# CITY OF ALBUQUERQUE

March 12, 2022

**Re: Champion Xpress Car Wash  
2020 Buena Vista Drive SE  
Traffic Circulation Layout  
Engineer's/Architect's Stamp NONE given (L15-D056)**

TCL Approval 03-17-22  
 Nilo Salgado-Fernandez

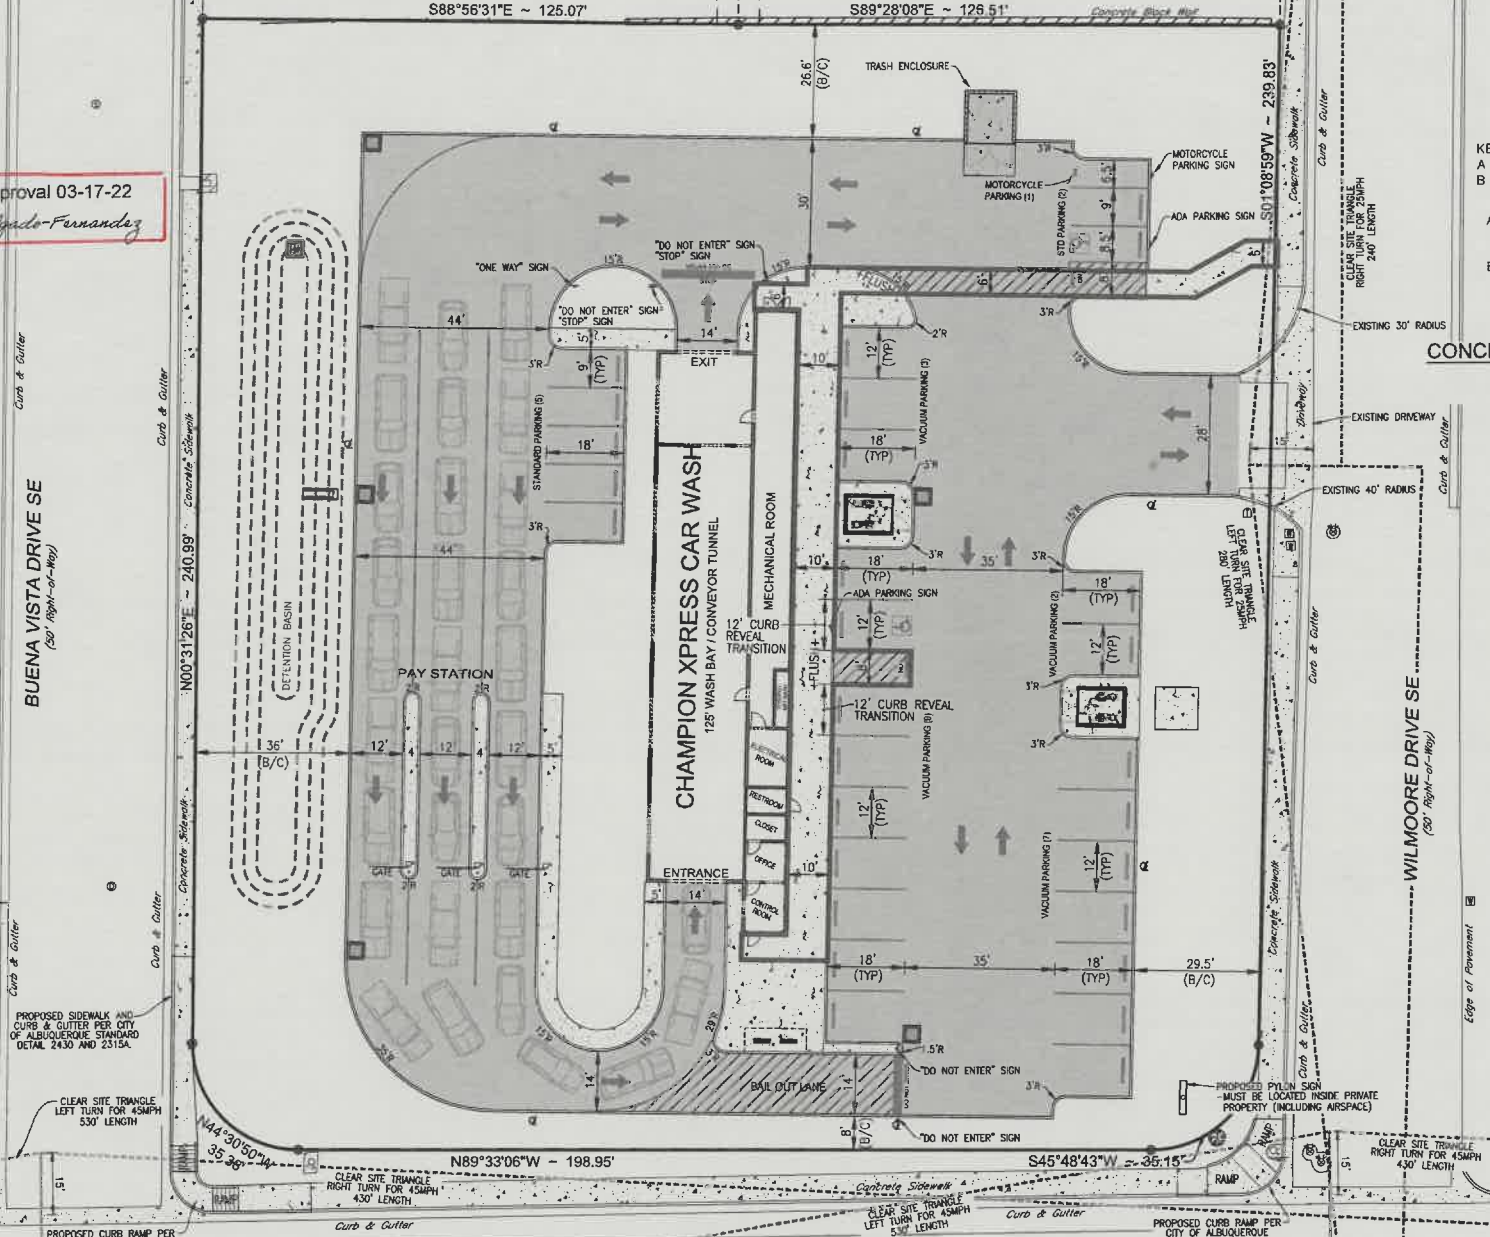
2. A copy of receipt of Resubmittal payment will need to be provided.
3. **Gibson/Buena Vista Corner:** The ramp will need to be replace since existing condition is not current/update per COA standards and will also need truncated domes/detactable surface.

4. **Gibson/Wilmoore Corner Ramps:** The existing is not current/updated COA standards and will need to be replace to comply.
5. Provide a copy of refuse approval **prior to TCL approval.**

7. Proposed Concrete Pavement: Provide the proposed thickness of concrete.
8. **"Do Not Enter" and "STOP" pavement markings:** Provide pavement detail for text and bar. **Prior comment not addressed or a detail provided. Please include crosswalk striping detail for proposed 6 ft pathway across drive aisle.**

9. Please provide a sight distance for Intersection Sight Distance (Per DPM- Minimum Intersection Sight Distance Table). **The Sight line are applicable on Gibson frontage with proposed landscaping so please provide this on Gibson with intesections of Buena Vista and Wilmoore.**

10. Please specify the City Standard Drawing Number when applicable.
11. Unused curb cuts must be replaced with sidewalk and curb & gutter. **A build note must be provided referring to the appropriate City Standard drawing (2430 & 2415A) on Buena Vista Drive driveway closure for Sheet C-2.0**
